**West Yorkshire Police
Kirklees District**

| To: Victor Grayson Kirklees Council Planning Services | Ref: 2020/92350 Date: 2 nd September 2020 |

**Proposed site: Land South of Heybeck Lane, Chidswell, Dewsbury
Outline planning application for: 181 Residential dwellings**

With reference to the **Illustrative Plan, drawing number 00-101 rev. D dated 14/02/2020.**

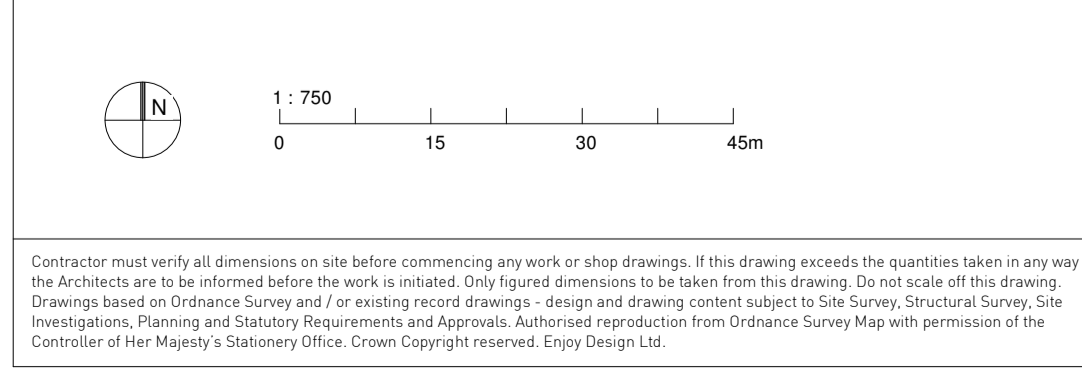
- Road layout – There are a number of roads within this development that are very straight. This can encourage motorists to drive at excessive speeds through the estates causing a danger to the public. Speed restrictions must be considered by introducing bends into the road or chicane designs.

- Clarification is required about the adoption of the Highways by the Local Authority - There are a significant number of small roads / “private drives”, leading to clusters of properties throughout the development. For crime reduction purposes, street lighting must be provided and maintained by the Local Authority Highways department, to all of these small roads or “private drives”.

- Rear garden access. See below advice section for properties with 3 or more blocks of dwellings.
- Tree and vegetation planting proposals. What will be the long-term maintenance plan?

- “Leaky” cul-de-sac’s encourage offenders and create escape routes. These require reviewing and security measures to be put in place to mitigate this risk.

- Access to properties via “Private Drives”. Lighting provisions to be confirmed.
- What are the boundary treatments to be at the end of the “Private Drives”?

- Proposed cycle route to the Local Centre. What are the lighting considerations?
